KIRKLEES METROPOLITAN COUNCIL INVESTMENT & REGENERATION SERVICE

DELEGATED DECISION TO DETERMINE PLANNING APPLICATIONS

Reference No:	2026/62/90043/W
Site Address:	The Cherries, 8, Rossefield Avenue, Birkby, Huddersfield, HD2 2BR
Description:	Erection of two storey side and single storey rear extensions
Recommending Officer:	Elenya Jackson

Drawing
Proposed Side ELevations

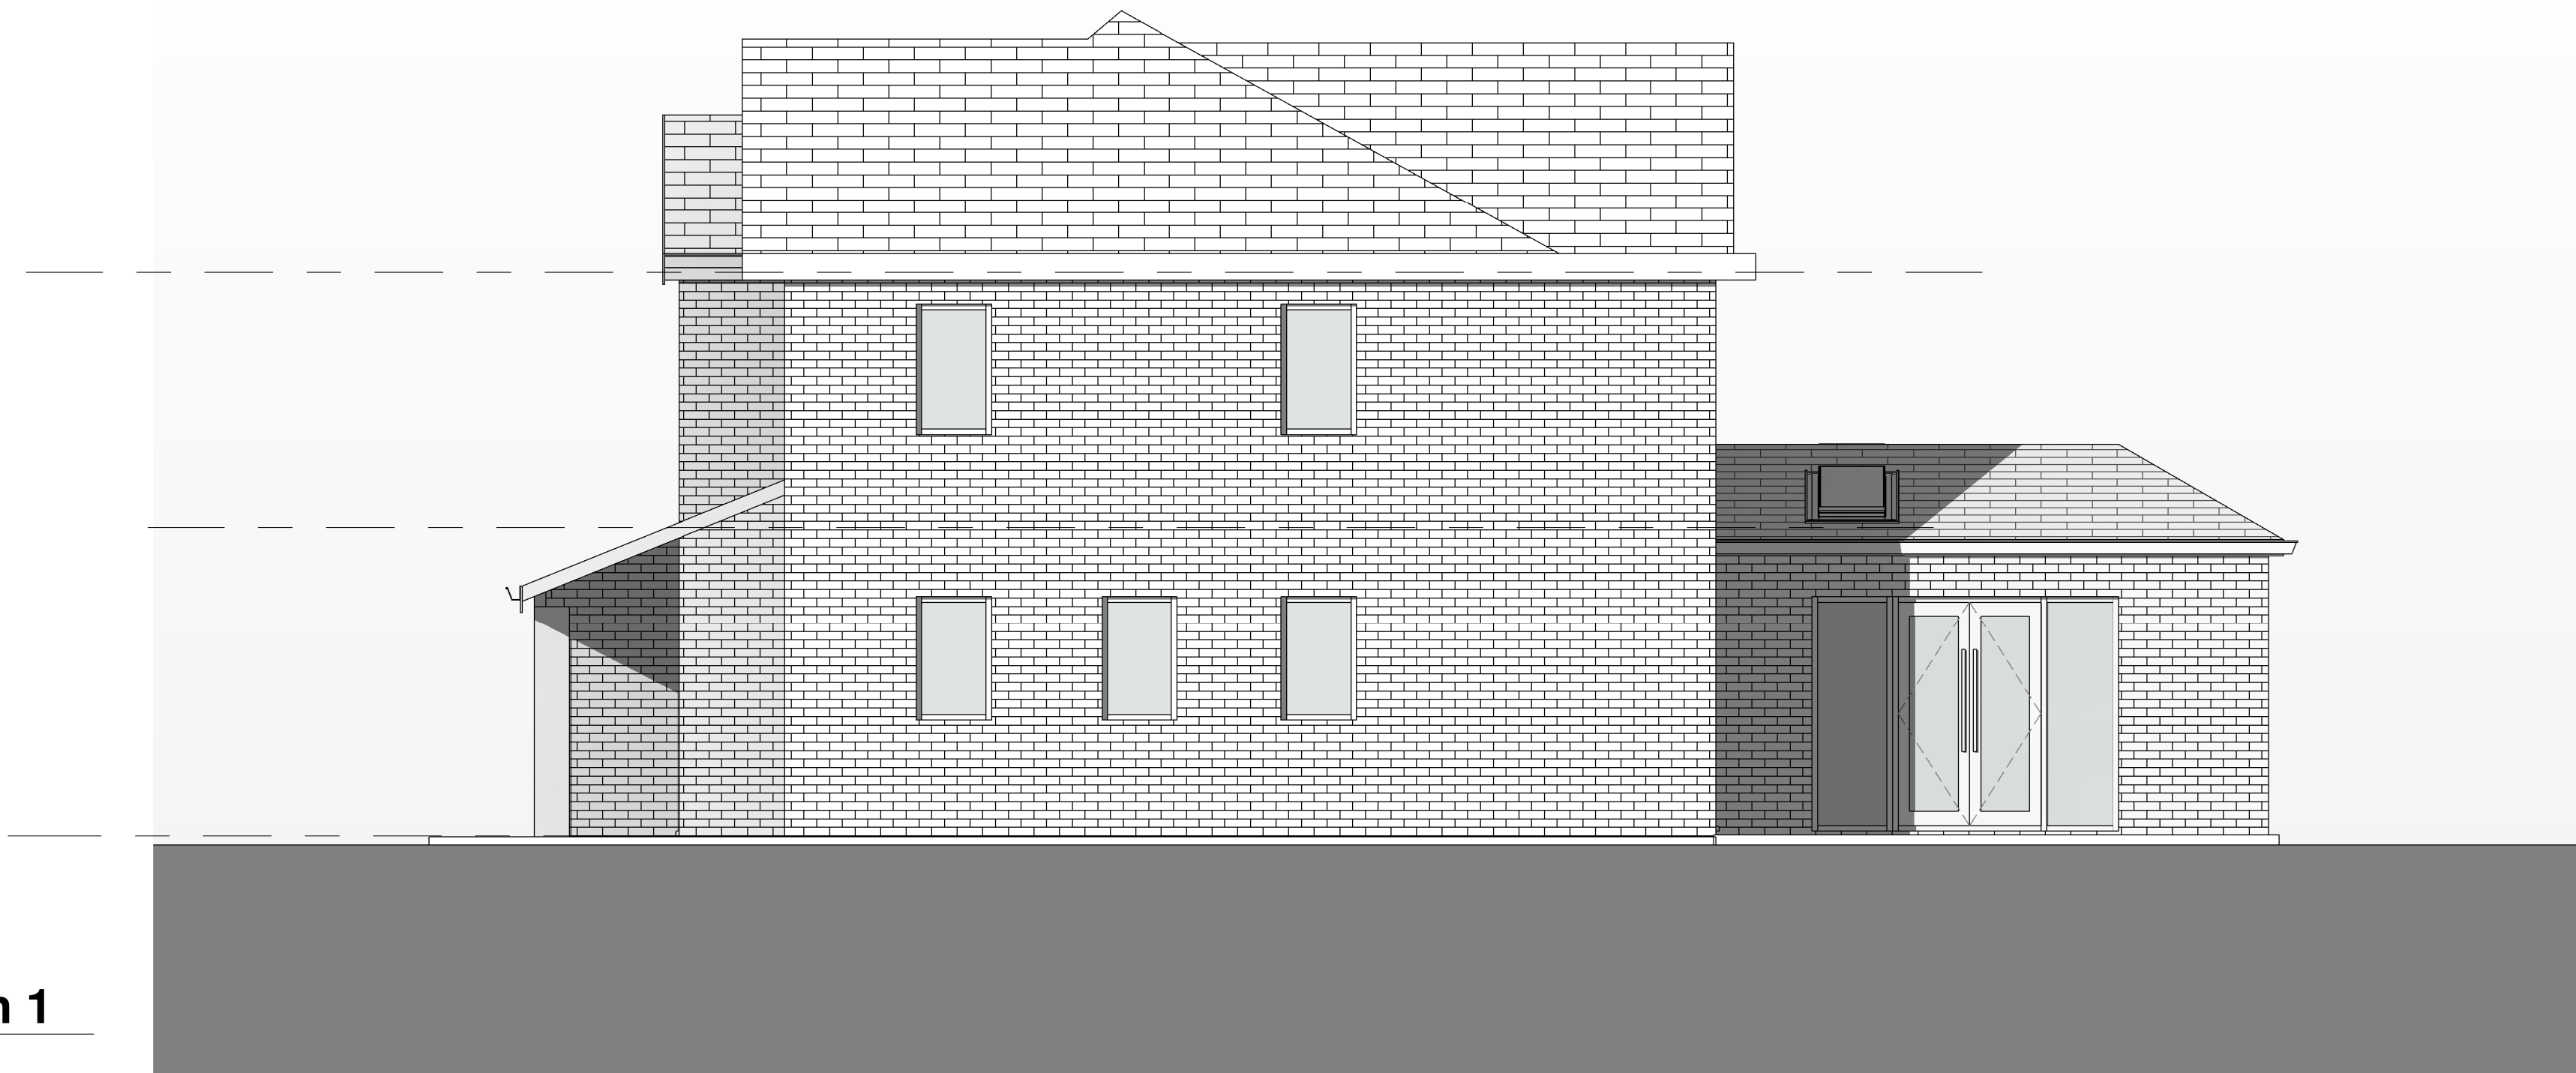
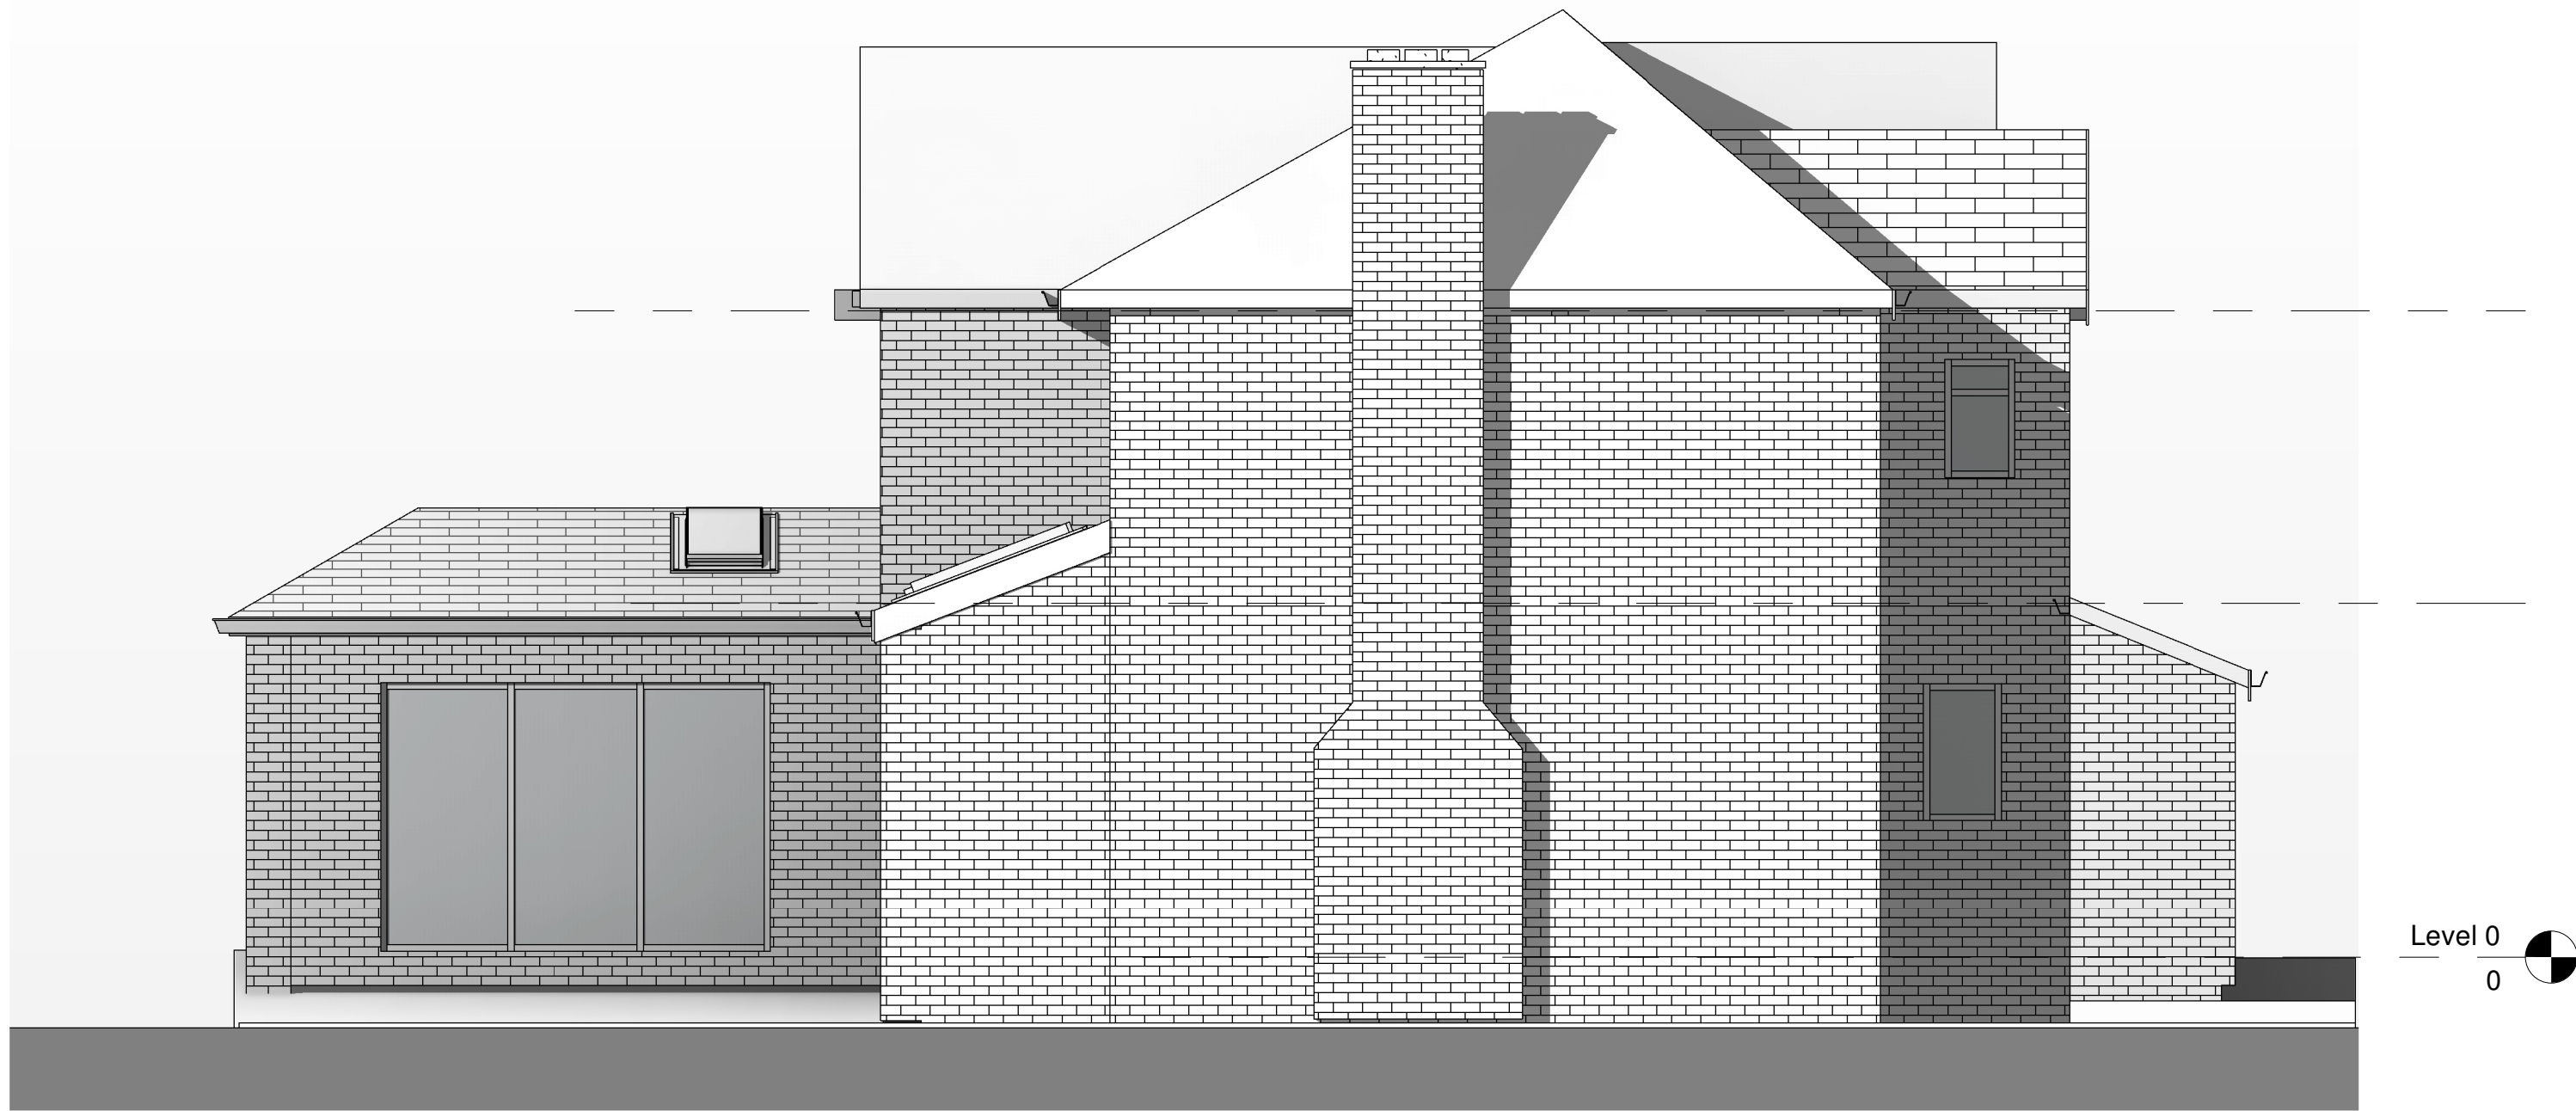
The existing dwelling has a single storey projection on its southern elevation. The two storey side extension would project 8.8m beyond the existing two storey element of the dwelling to the south. This would feature a gable end with a maximum height of 7m and an eaves height matching the existing dwelling.

Drawing
Proposed Front and Rear Elevations

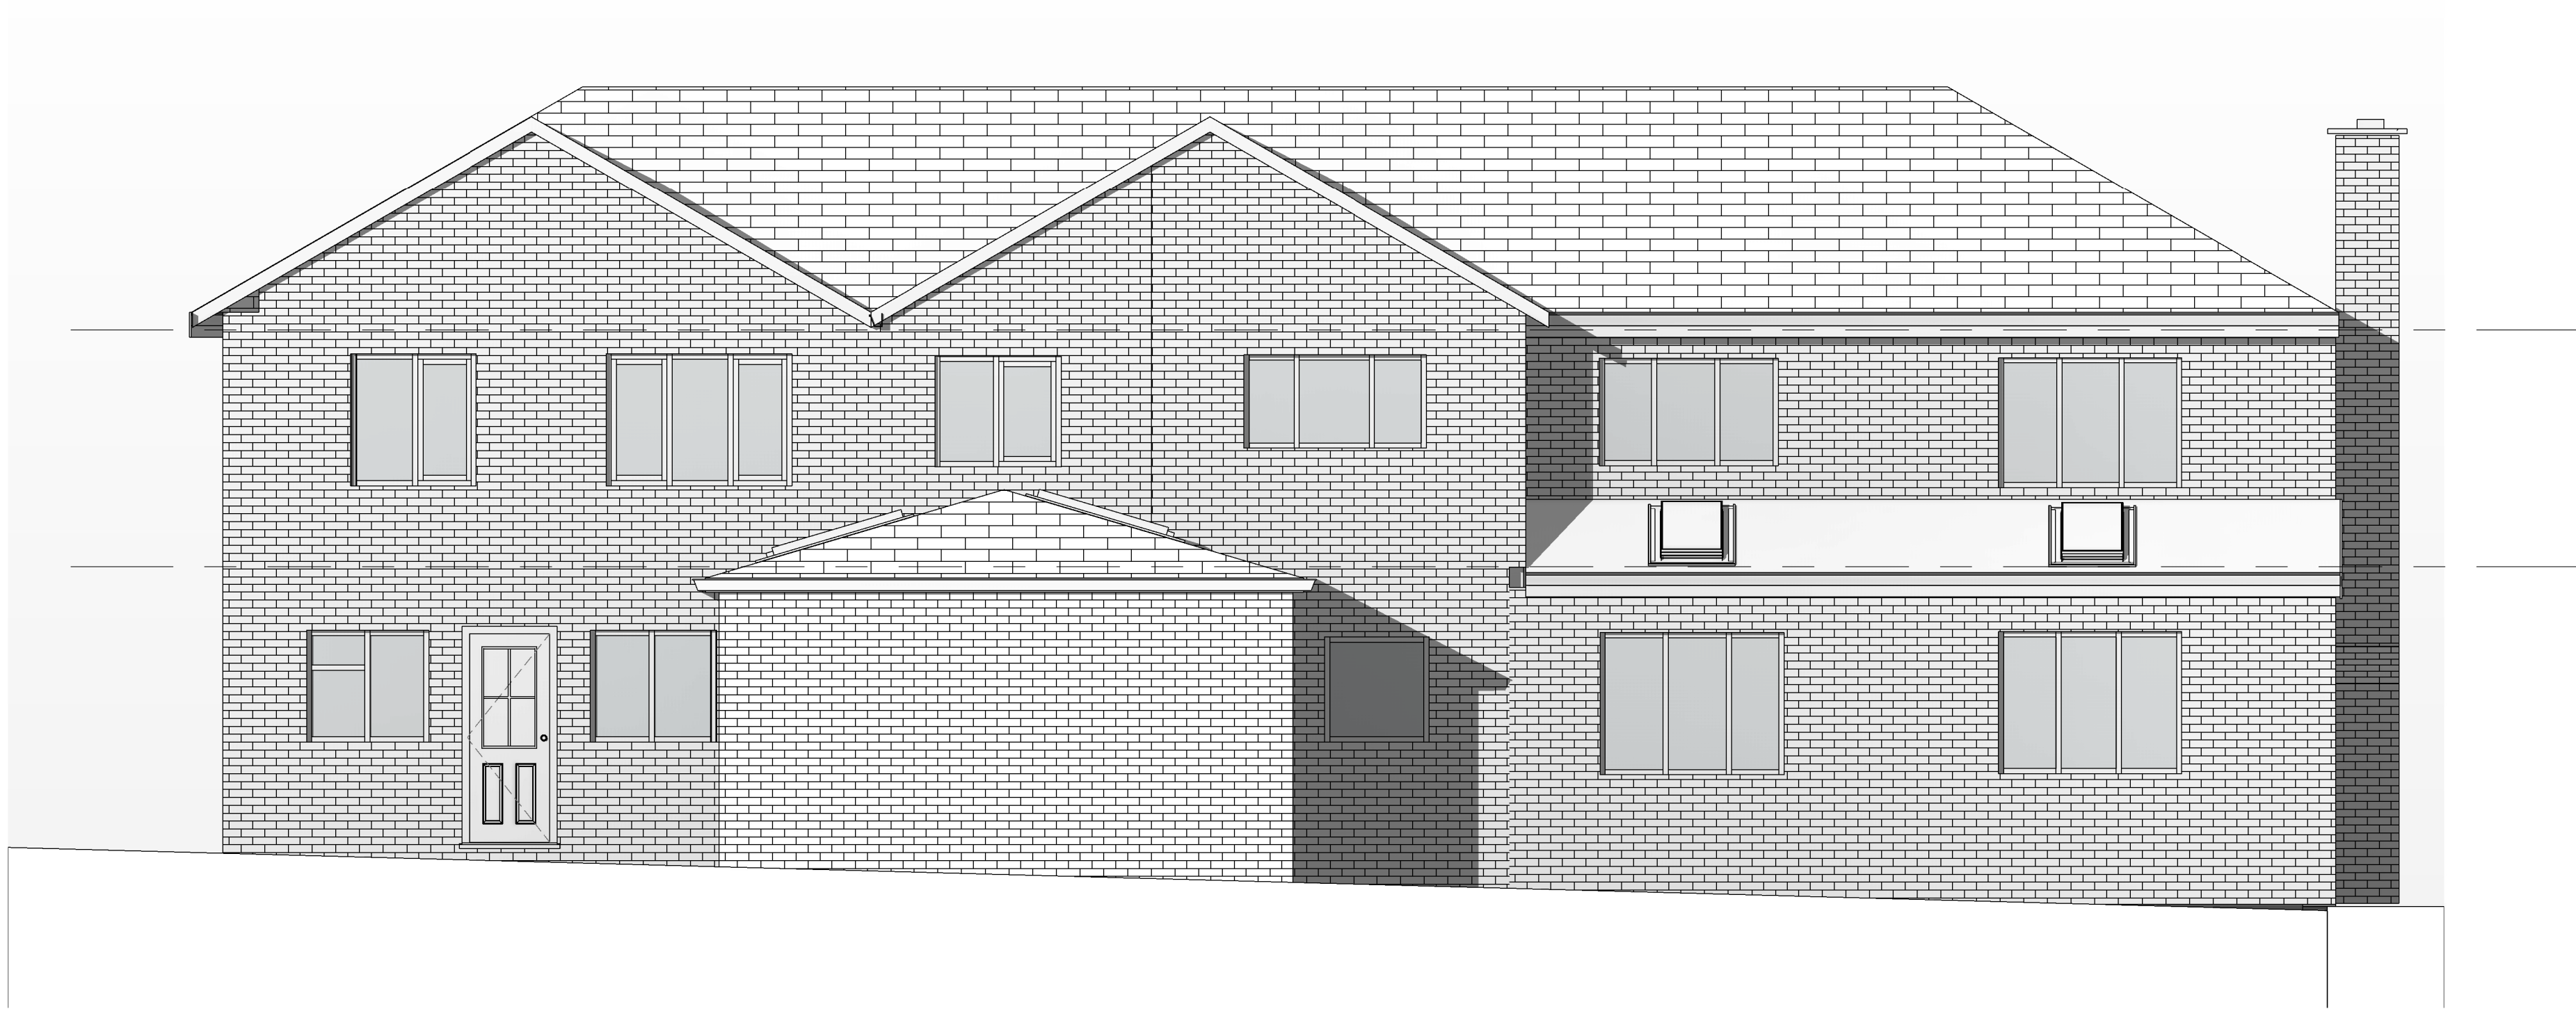
The single storey rear alterations would include the addition of a lean-to roof over the existing rear elevation of the property and the replacement of an existing orangery with a single storey hipped roof extension. This would extend 4.8m beyond the rear elevation of the host property and have a width of 5.5m and a maximum height of 3.6m.

Overlooking: The proposal would introduce rear facing windows at first floor level on the southern elevation of the site. It is considered that the windows would have an offset relationship with the rear of these properties and would retain the existing separation distance. Therefore, no significant issues would be raised regarding overlooking.
